To: Elizabeth Carpenter
From: Dean Brodie
CC: Katherine Tracey, Aaron Chandler
Date: 20 September 2017
Re: Proposed Inner West High School – Response to Authority Comments

RMS Letter Dated 24 August 2017

Transport for NSW Letter

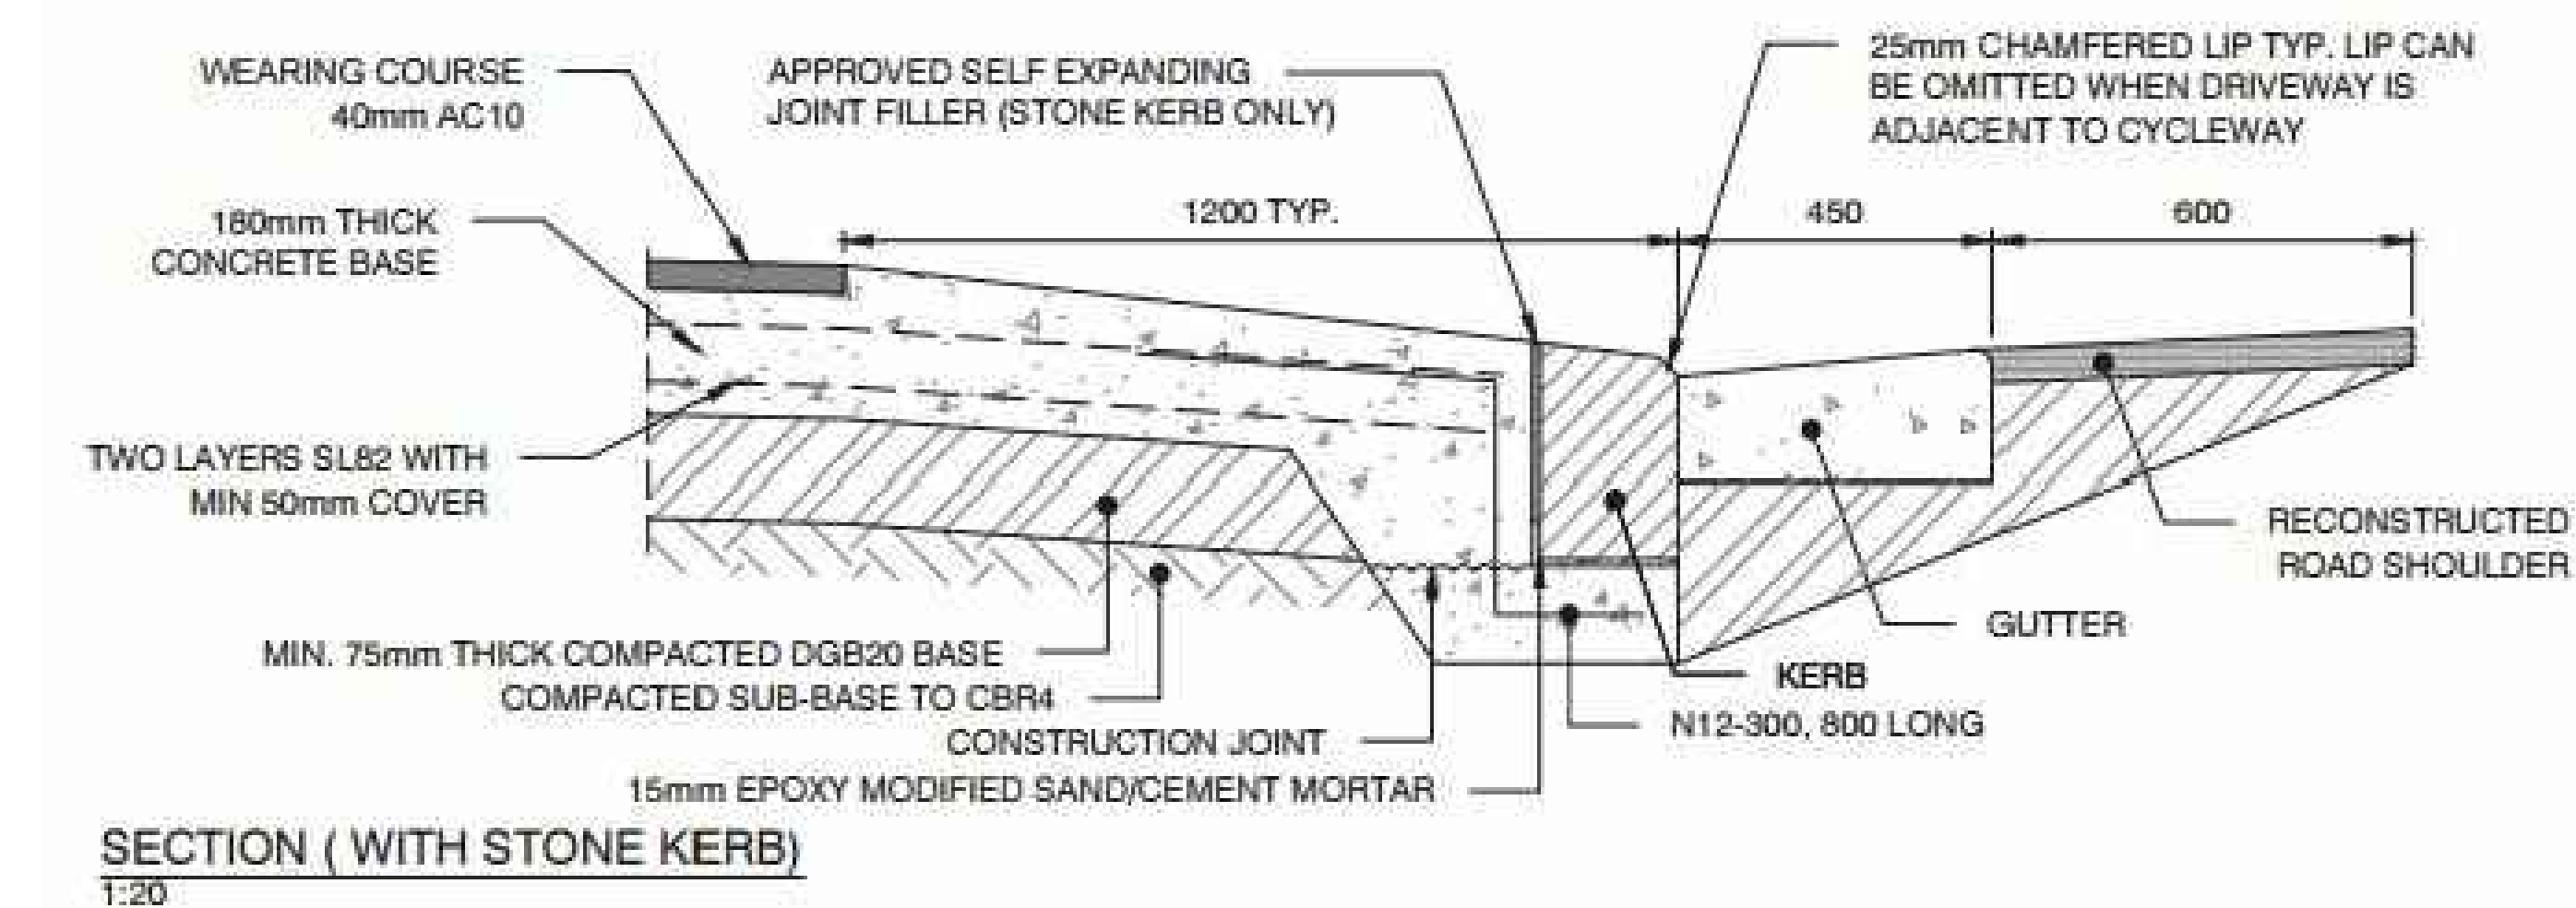
The vehicle swept path plan provided does not show detail of the vehicle crossover on Cleveland Street. The swept path plan should be amended to show detail of the crossover and driveway to demonstrate that the largest design vehicle can enter and exit the site in a forward direction, and manoeuvre to loading areas. Should any driveway adjustment works be required, this should be identified in the plans and submitted for Roads and Maritime's review.

The turn path presented in Appendix B of the report needs to include the driveway 'wings' either side of accommodate the turn path as shown below:
